From: MONICA and MARK ROBBINS
To: [Lauren Anderson](#)
Cc: [McIntosh Janet & Dick](#); [Kurt Bulmer](#); [Miriam Bulmer](#)
Subject: File Nos.: CA017-005, DEV17-009, ADU17-003, SHL17-007, SUB17-004--The Lady Bug Trust
Date: Tuesday, May 30, 2017 10:32:54 AM

We have had a chance to do a review of the documents that you forwarded regarding the above noted project located to the north of our property. We have the following comments on this project.

OGDEN POINT RESIDENCE

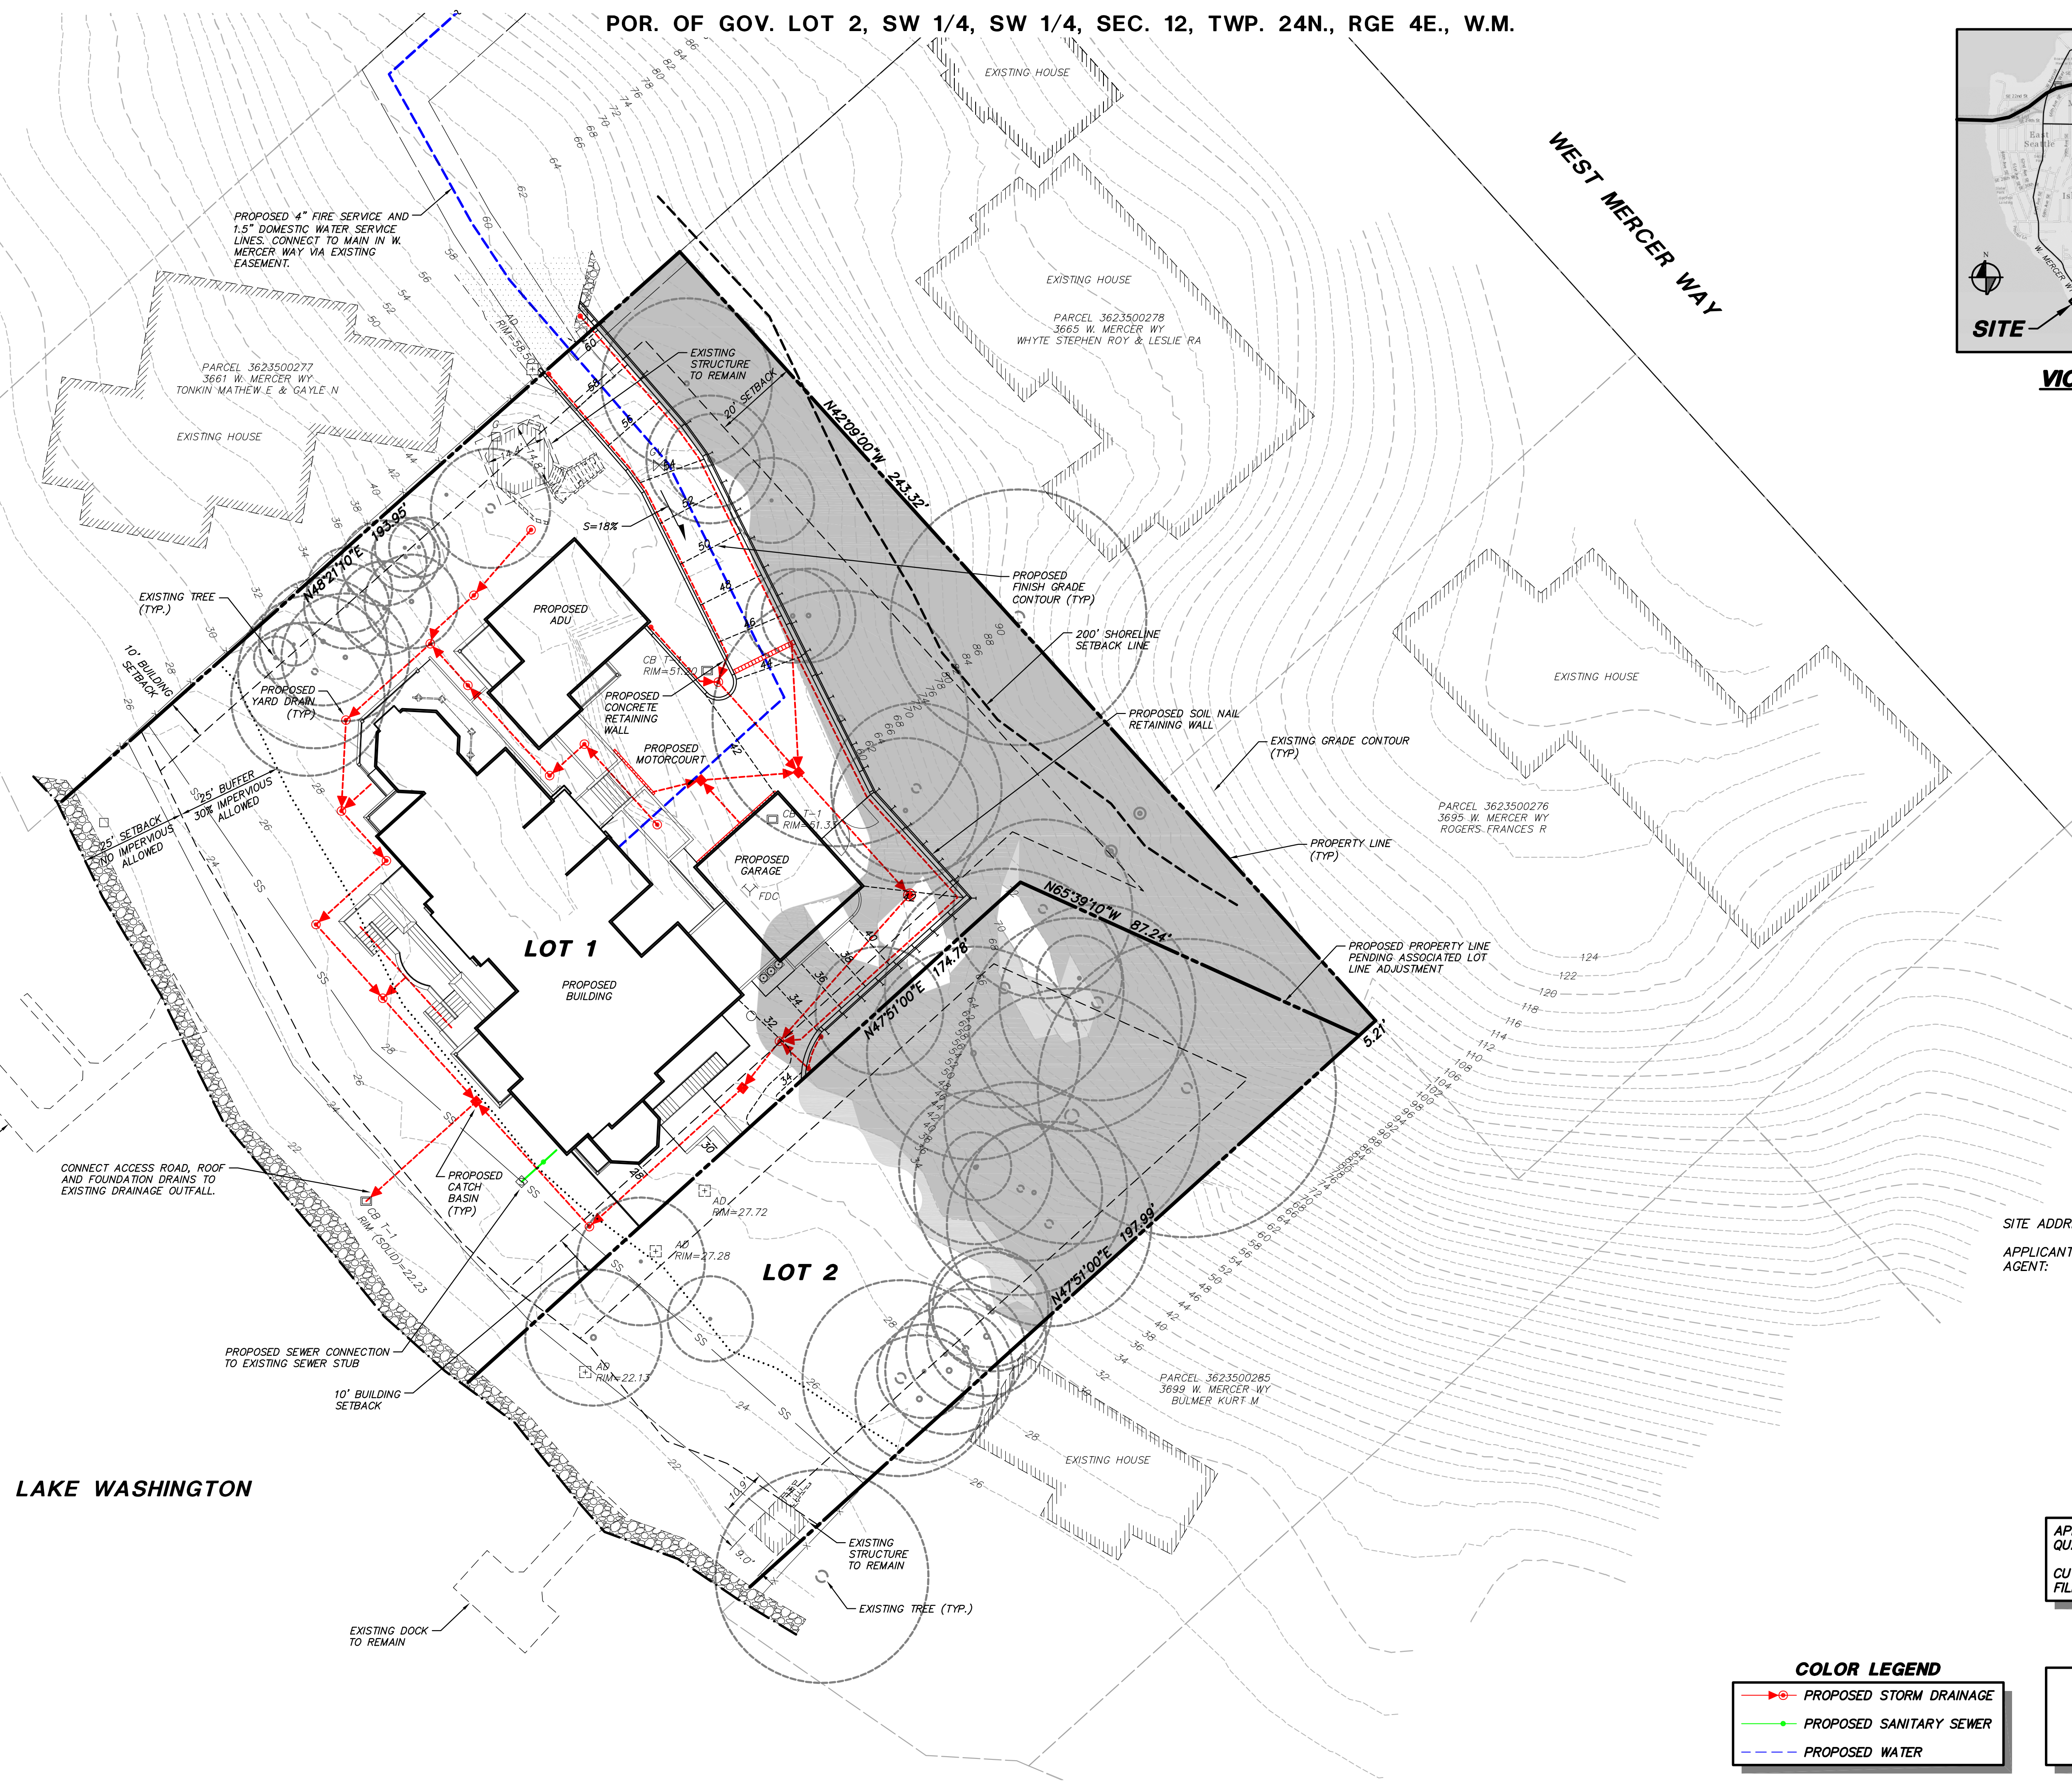
4. No details for the dock expansion are included in this application other than a general outline on the site plan showing a much larger dock with added covered boat moorage and a very long pier. We hope to have a chance to review the Substantial Development Permit referenced to determine the impacts of this additional significant aspect of the project.
